CITY OF ALBUQUERQUE

**Re: Bralco Metals, 6718 Jefferson NE,
Permanent Certificate of Occupancy - Approved
Engineer's Stamp dated: 04-27-11 (E-17/D072)
Certification dated: 06-14-11**

Re: Bralco Metals
Drainage and Grading Plan
Engineer's Stamp dated 4-15-11 (E17/D072)

Re: Bralco Metals
Drainage and Grading Plan
Engineer's Stamp dated 6-14-11 (E17/D072)

### SECTION A-A

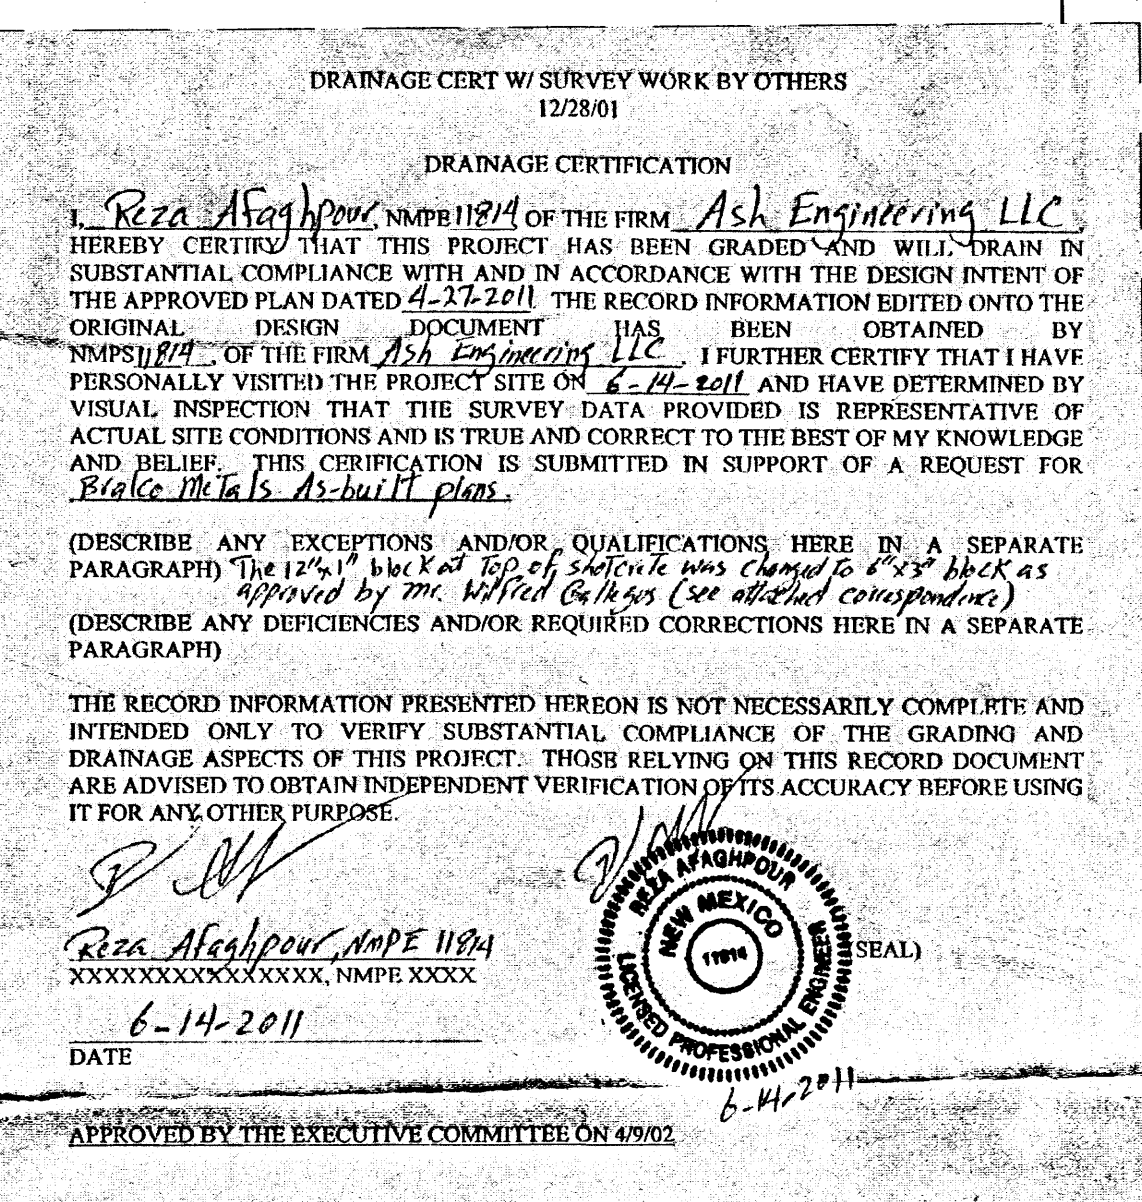
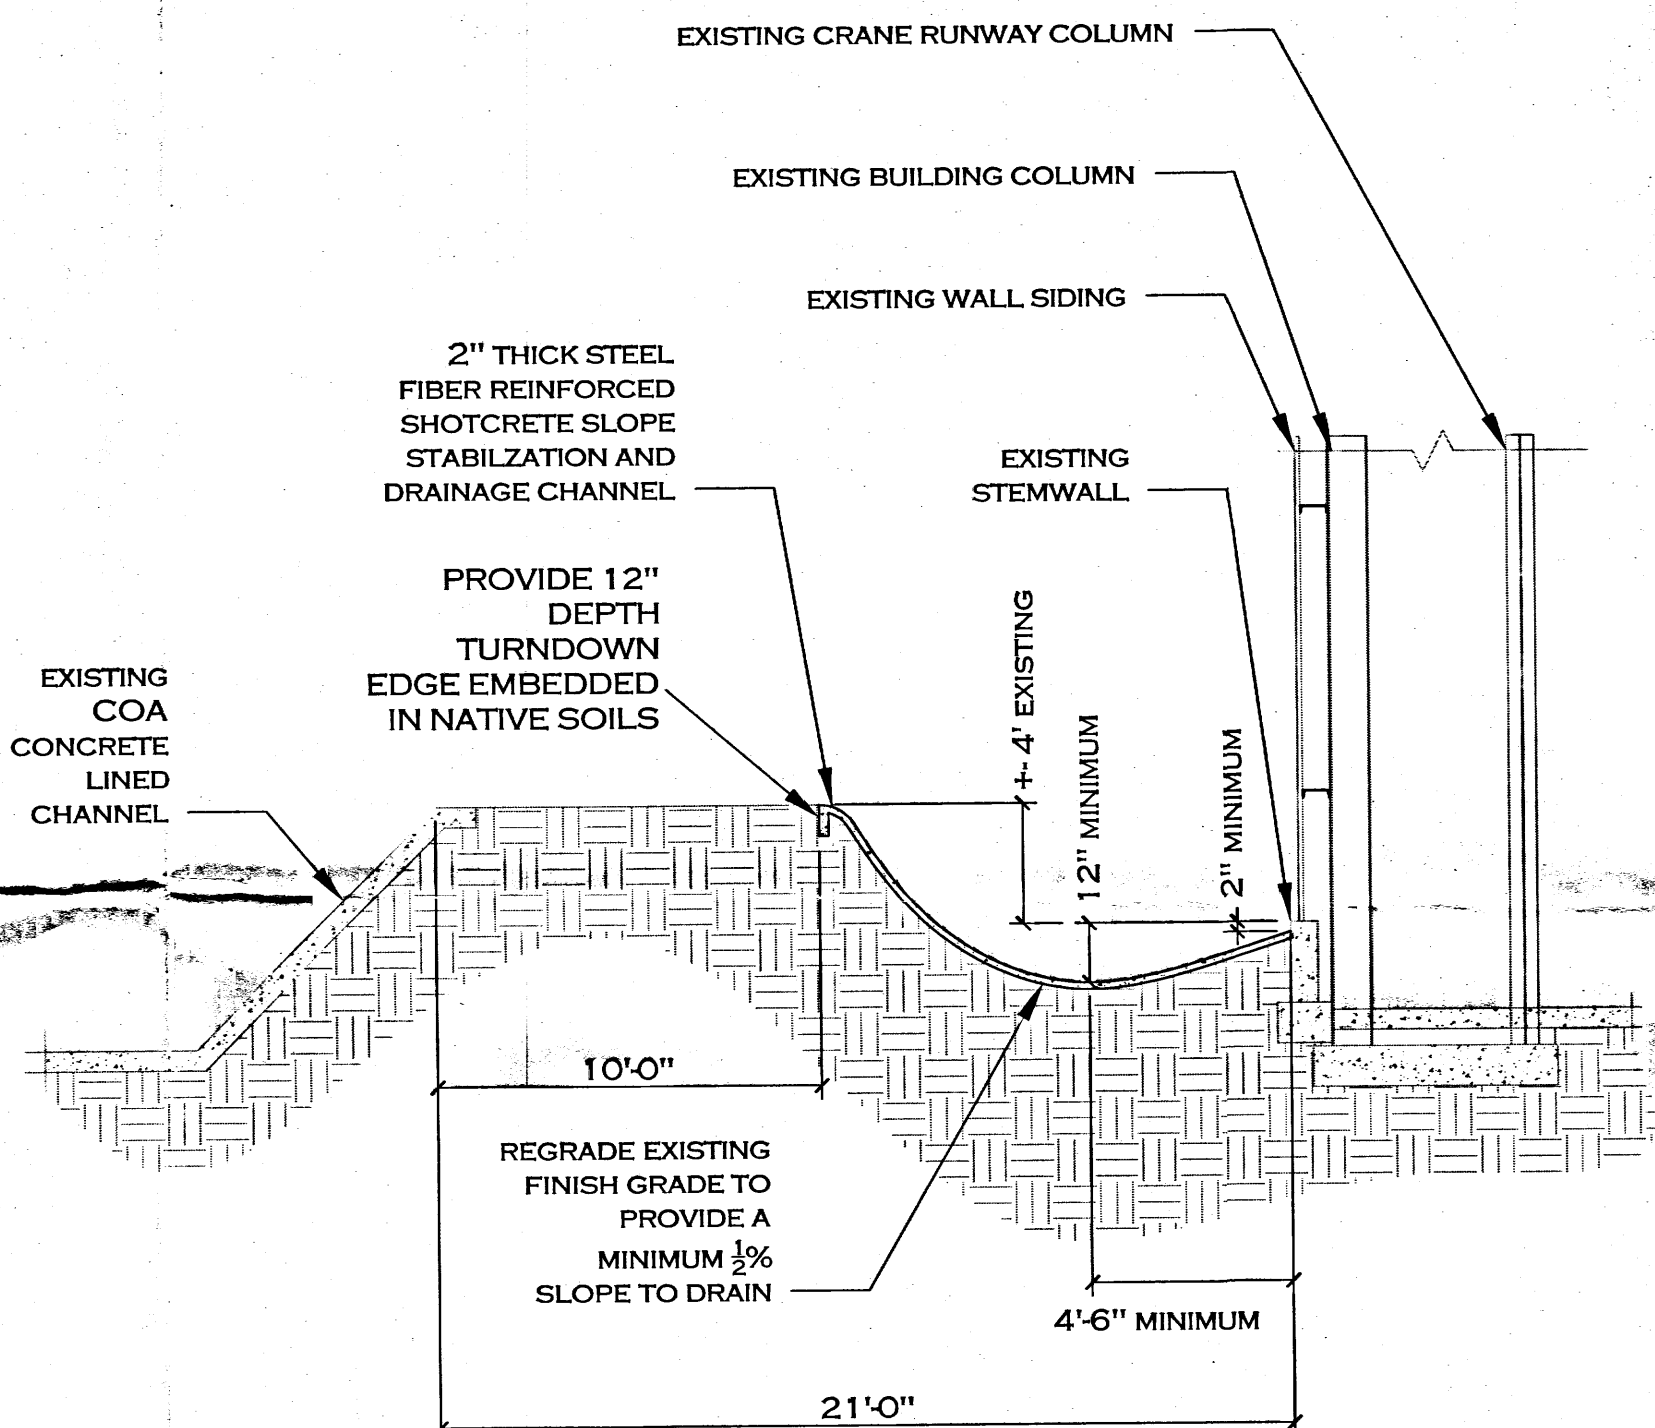
- Place the Drainage Certification language on the Grading and Drainage plan.
- A letter or email of approval is received from Storm Drain Maintenance.

(DESCRIBE ANY EXCEPTIONS AND/OR QUALIFICATIONS HERE IN A SEPARATE
PARAGRAPH) The 12"x1" block at top of shotcrete was changed to 6"x3" block as
approved by Mr. Wilfred Gallegos (see attached correspondence)

SECTION A-A

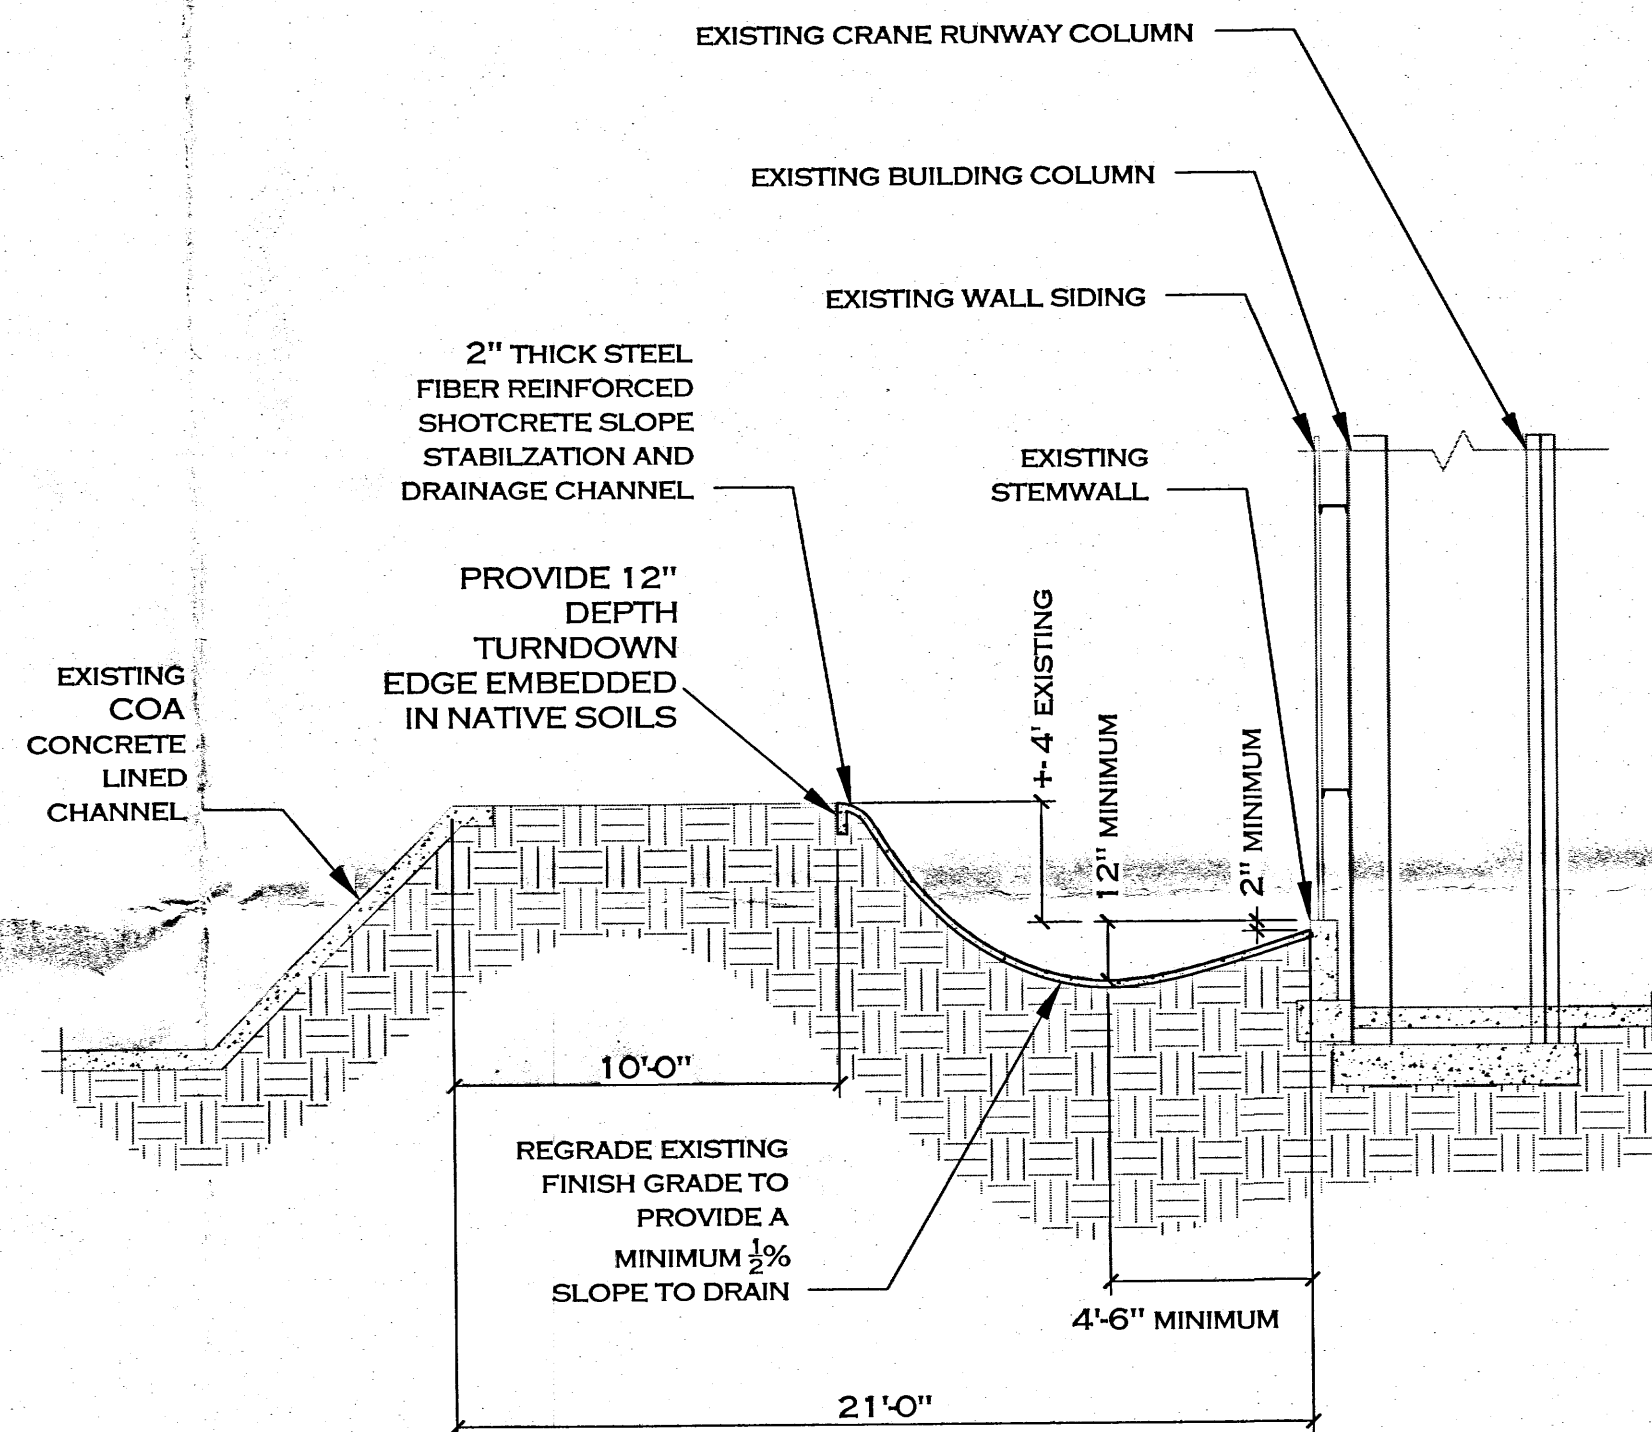
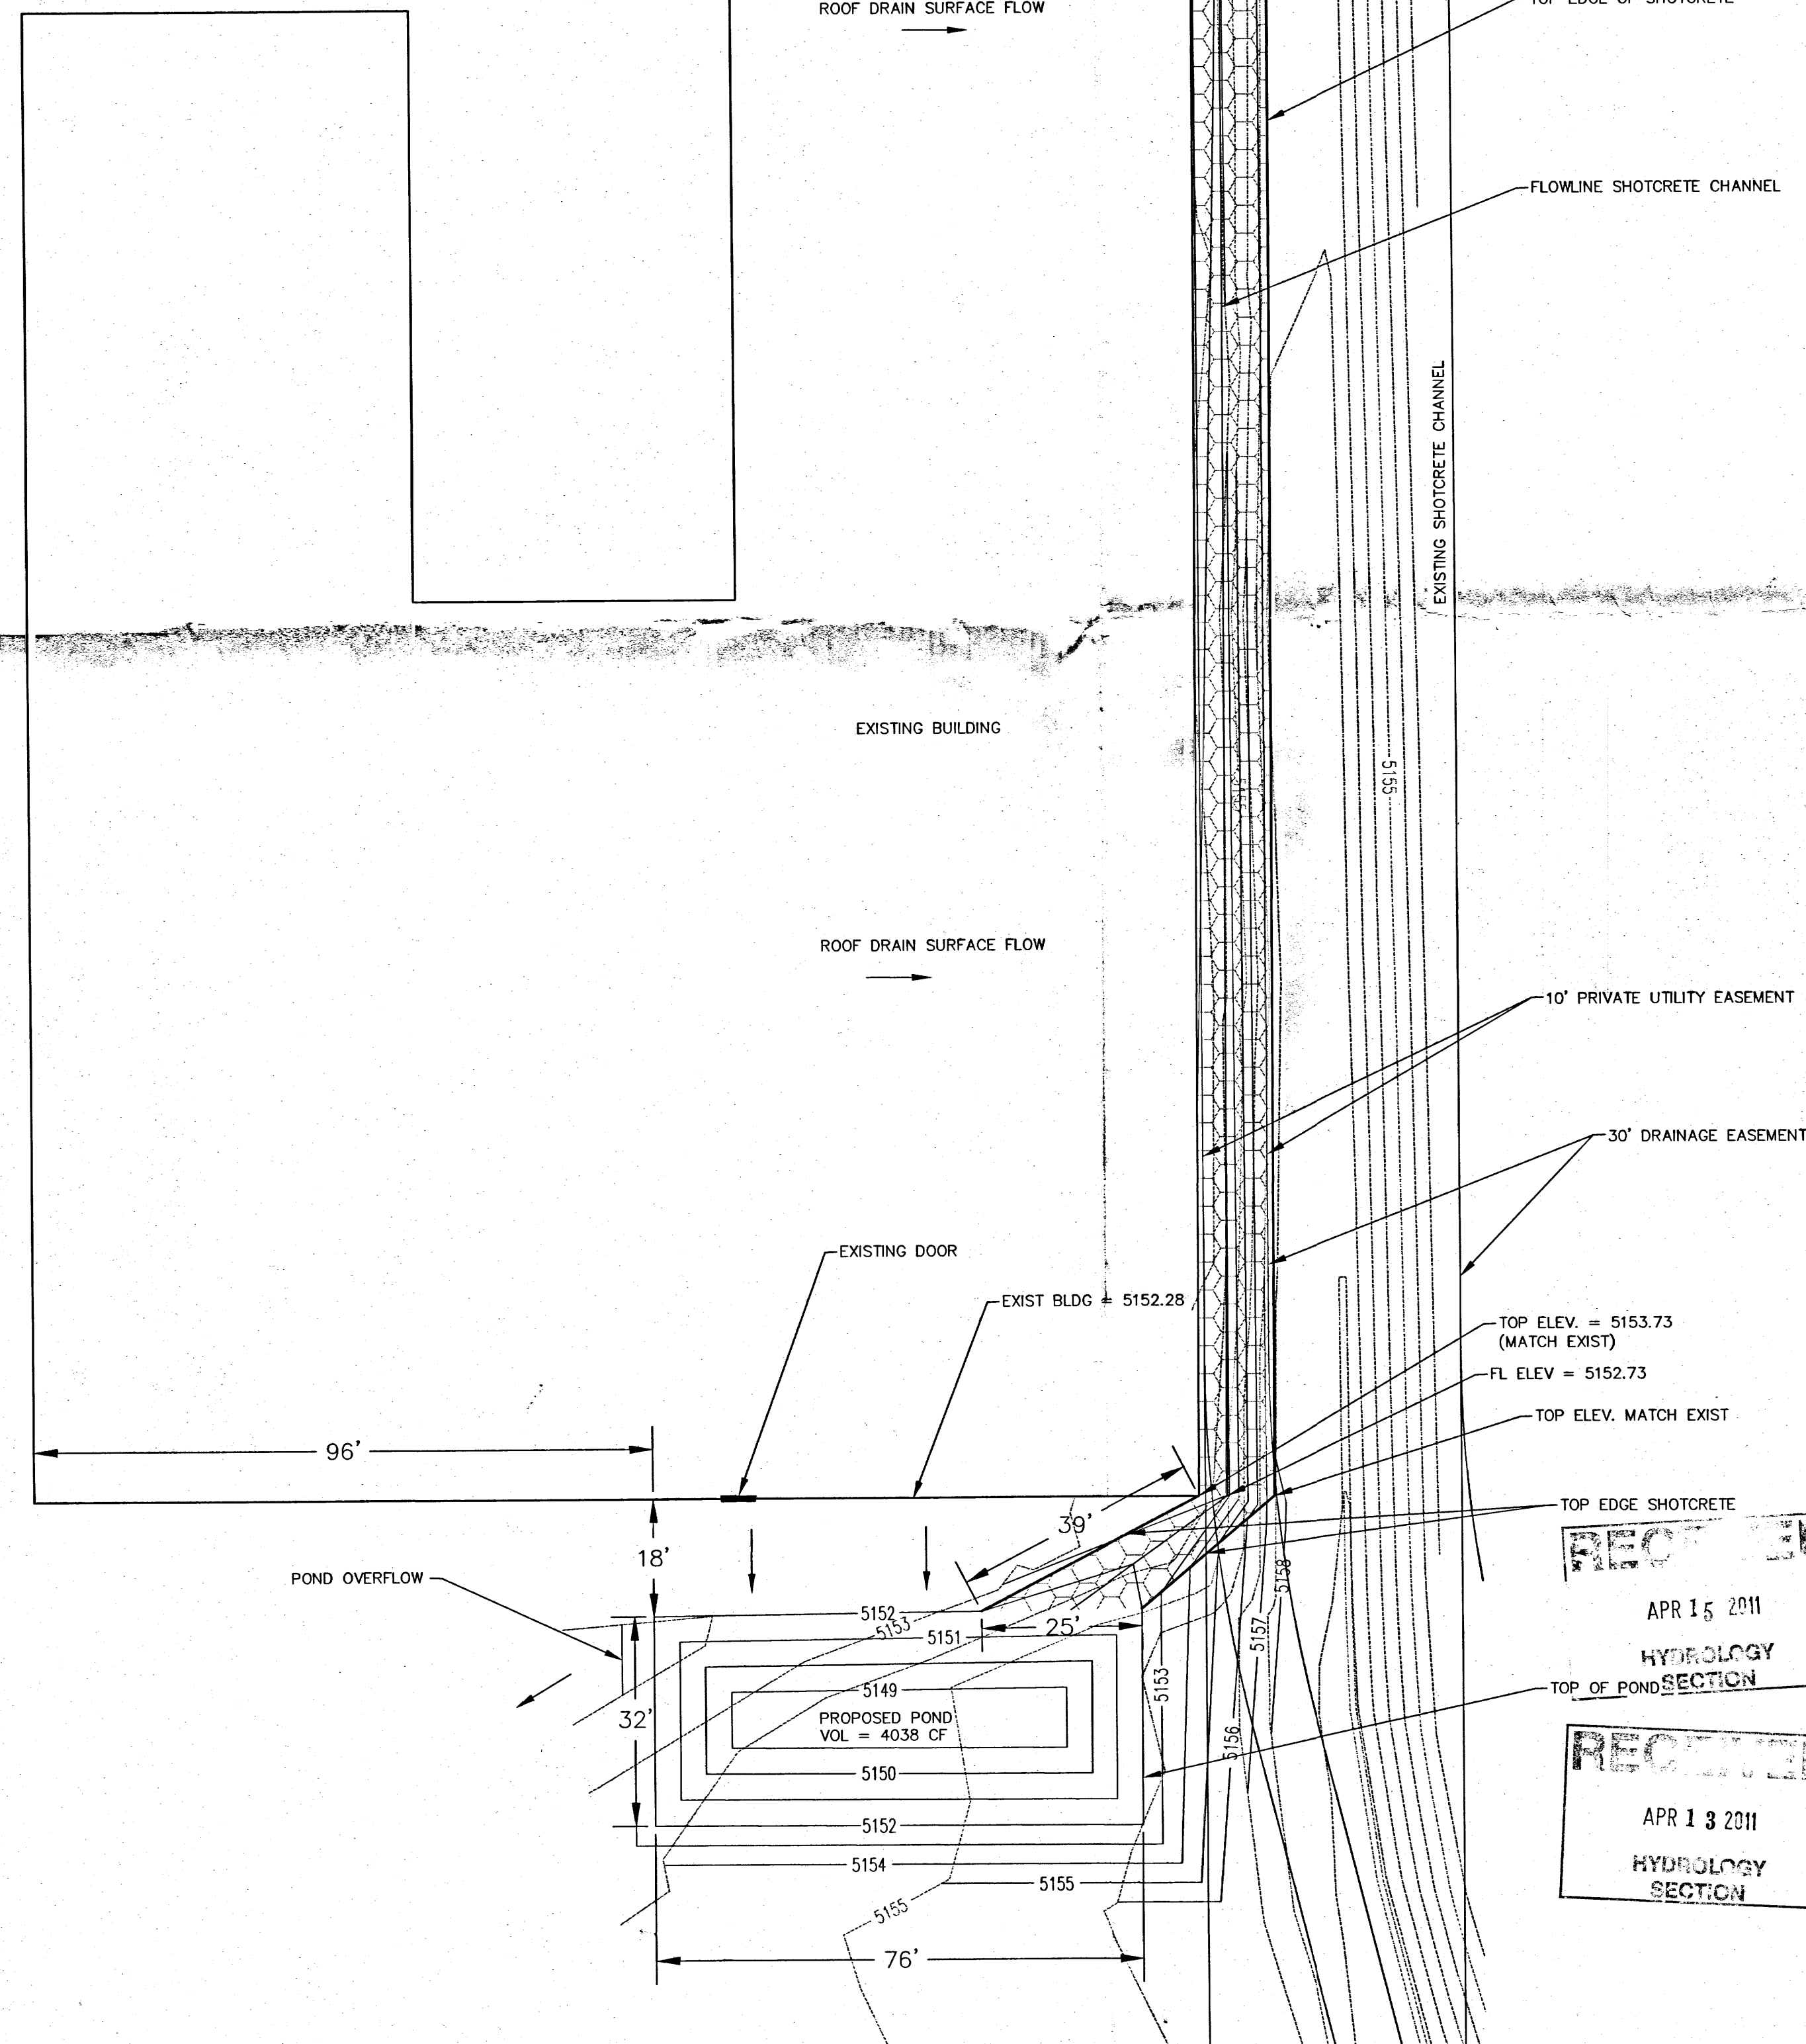
I also had him add a narrative and the cut-off wall on the shotcrete.

As discussed today I've done a hand drawing of the small change in the Bralco Metals shotcrete turndown, and I've talked to Curtis, and he's given his okay with the design. The approved turndown has a 12"

depth right next to the steep slope, and it is almost impossible to dig the 12" down without sloughing off the top of the slope. I recommend a 6" deep thickened edge instead with a 3" flat top. The 6" depth will have 3" buried and 3" exposed. Please see the attached drawing for details.

Based upon the information provided in your submittal received 6-14-11, the above referenced plan can not be accepted for certification until the following comments are addressed:

I would rather that you mirror the other side. (ie. have flat area on top of the maintenance road - - maybe 1' or so) I assume that the owner knows he is responsible for this.....
